From: Laura Gibbons
Sent: 19 July 2018 11:45
To: Planning.Responses
Subject: RE: Planning Consultation on: AL/57/18/OUT

Engineers Comments Relating to Surface Water Drainage

NOTIFICATION FROM ARUN DISTRICT COUNCIL
Town & Country Planning Act 1990 (as amended)
Town & country Planning (Development Management Procedure) (England) Order 2015 -
Article 5
Outline Consent
APPLICATION AL/57/18/OUT
NO:

Description of Works: Outline application with some matters reserved for the erection of 30 No. dwellings consisting of 4 No. 4-bed houses, 10 No. 3-bed houses, 4 No. 3- bed apartments, 8 No. 2-bed apartments & 4 No. 1-bed apartments, communal work hub with associated car parking & landscaping. This application is a Departure from the Development Plan.

CLIENT	STILES HAROLD WILLIAMS
PROJECT	WOODGATE
DRAWING TITLE	DRAINAGE STRATEGY
DRAWN/DESIGN	AHB/AHB
SCALE	1:250 @A1
MLM REF	618719
STATUS	S2
REVISION	P04
PROJECT	ORIGINATOR
VOLUME/ LOCATIONS	LEVELS & SYSTEM
TYPE	ROLE
NUMBER	618719- MLM - ZZ - XX -DR- C -0001

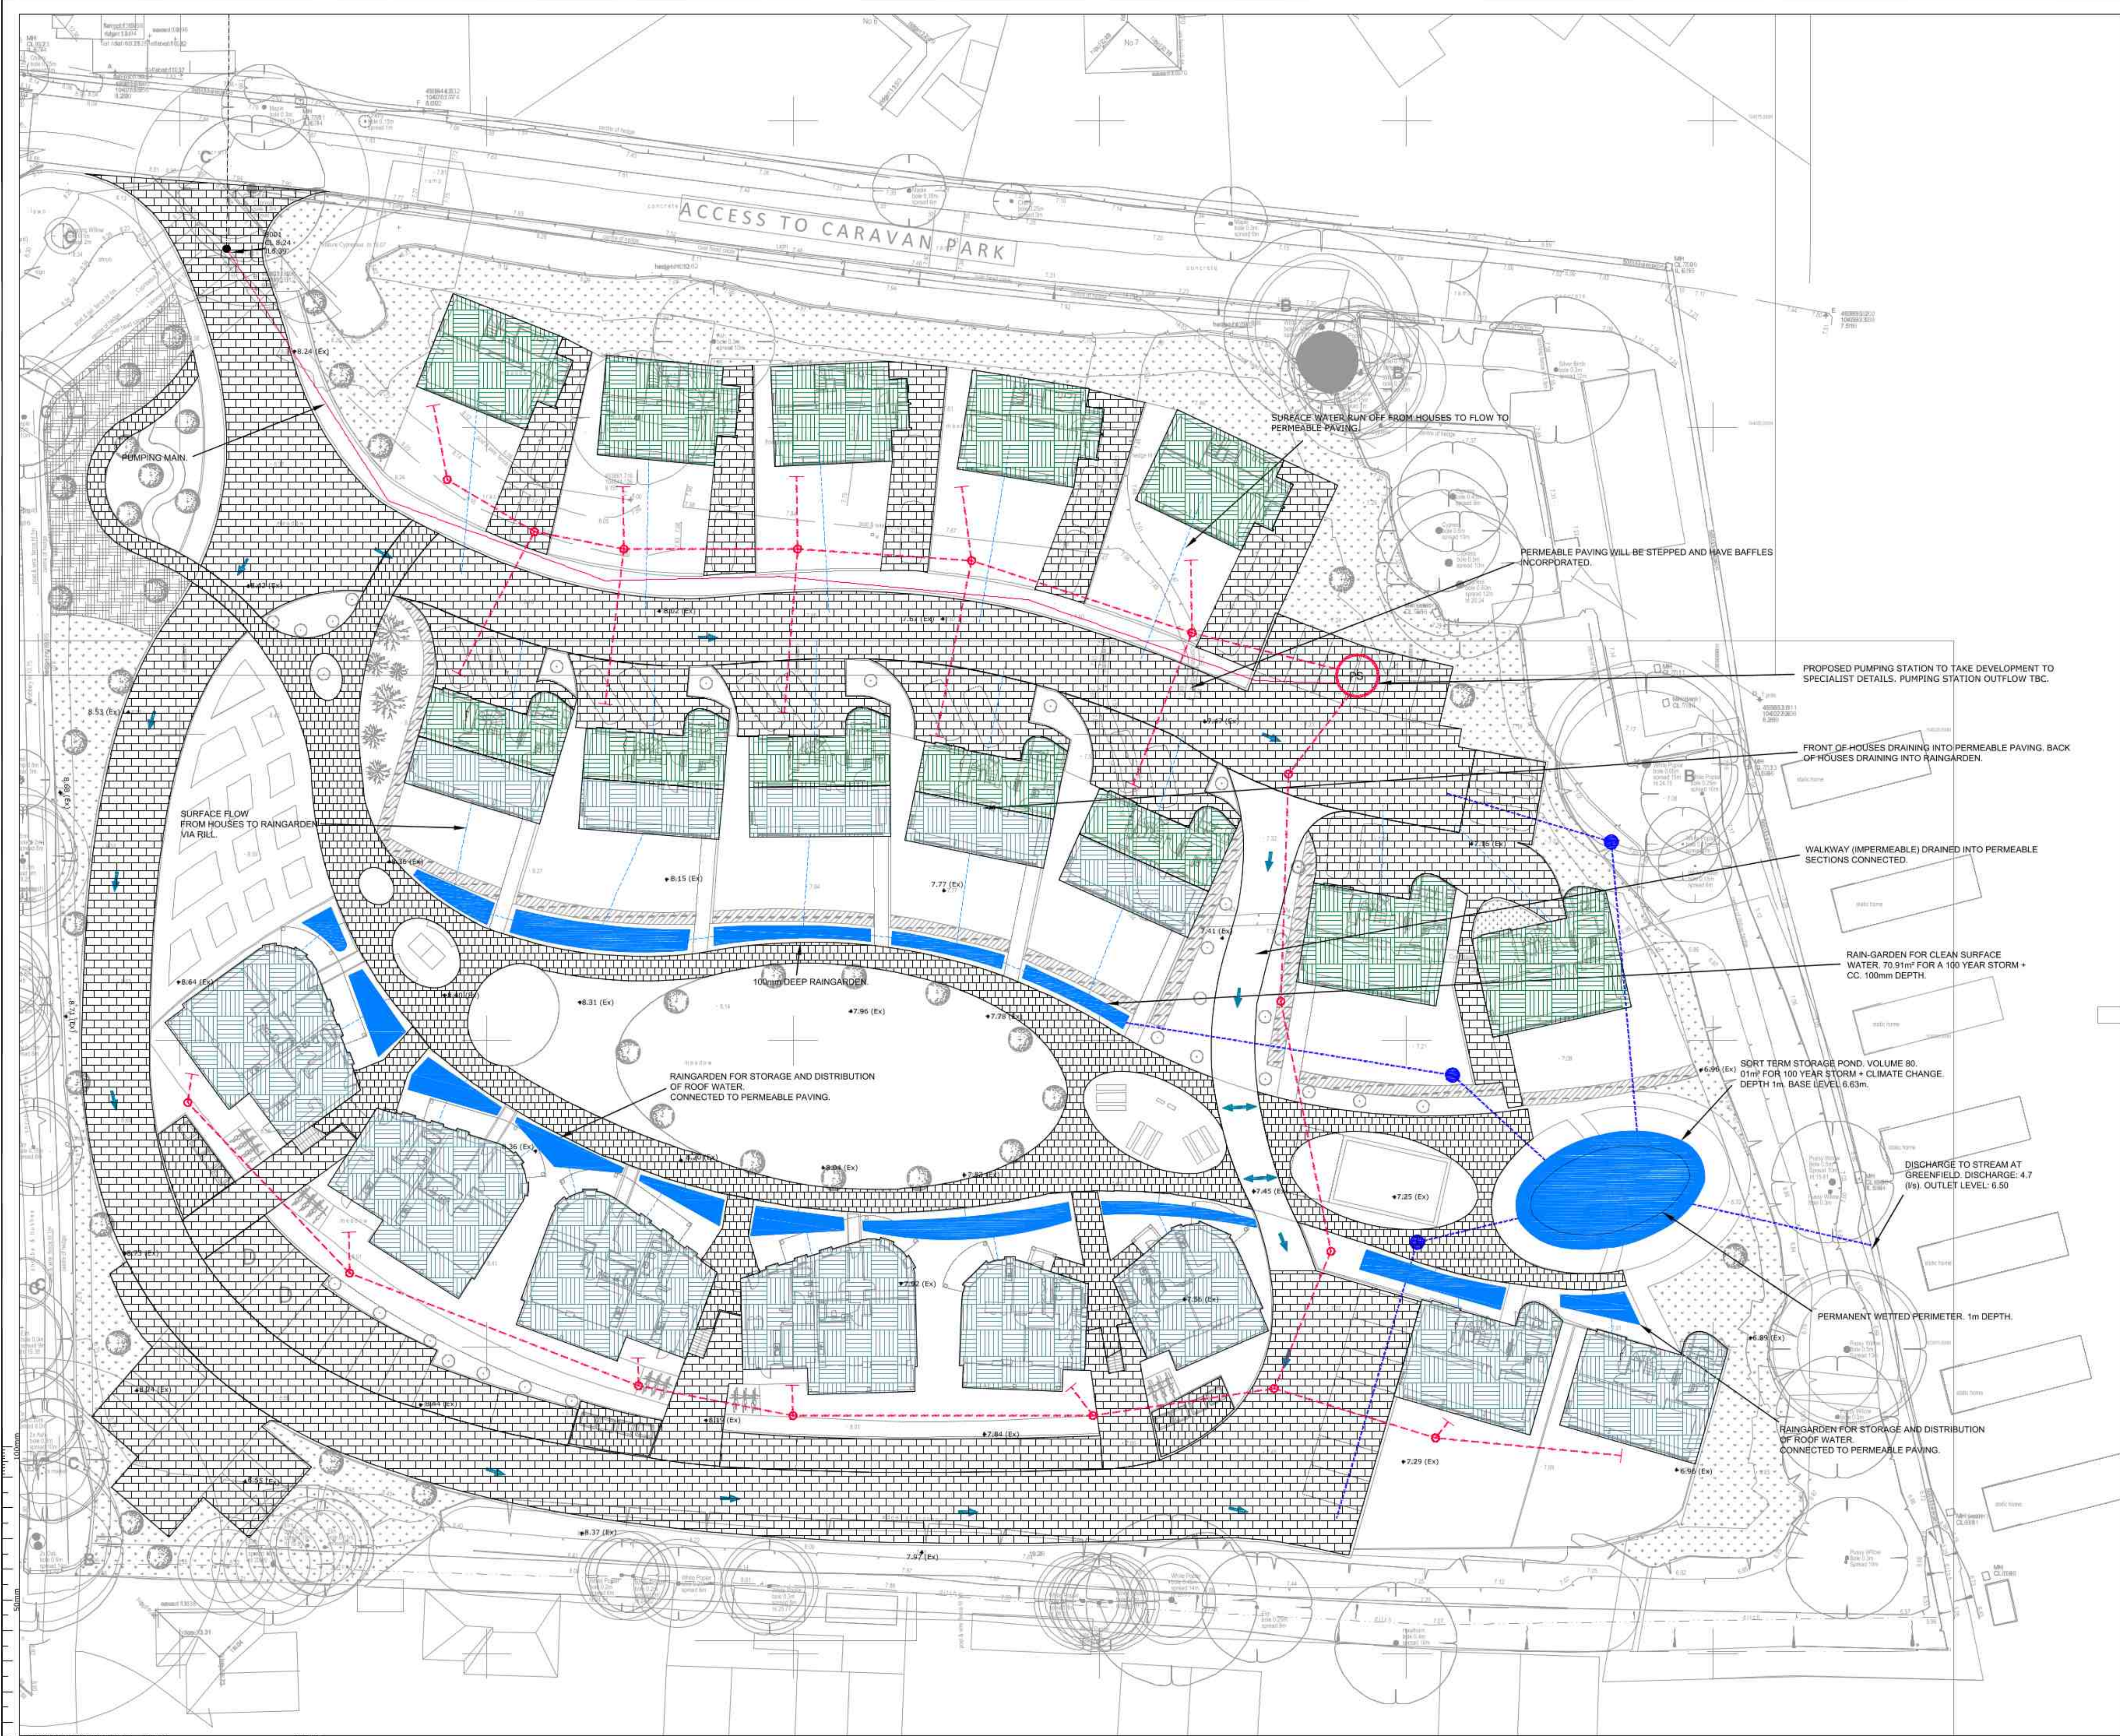
Infiltration must be investigated for surface water disposal. No evidence has been submitted to support the statement that the site is not suitable for infiltration. Winter groundwater monitoring and percolation test results will need to be submitted.

It should be noted that there is an area of surface water flood risk to the east of the site, any proposals to develop in this will need to be accompanied by evidence that development will not increase flood risk elsewhere and the risk to the proposed development is reduced, i.e. finished floor levels set to appropriate levels above flood levels.

There is a watercourse running to the east of the site, no development should occur within 3m of this. Any proposals to connect to a culverted watercourse will need land drainage consent, which can be sought through us.

It should also be noted that the current proposed discharge rate is unacceptable. The justification for a discharge rate 4.9l/s based on the principles of blockage is insufficient, rates of 2.5l/s can be achieved.
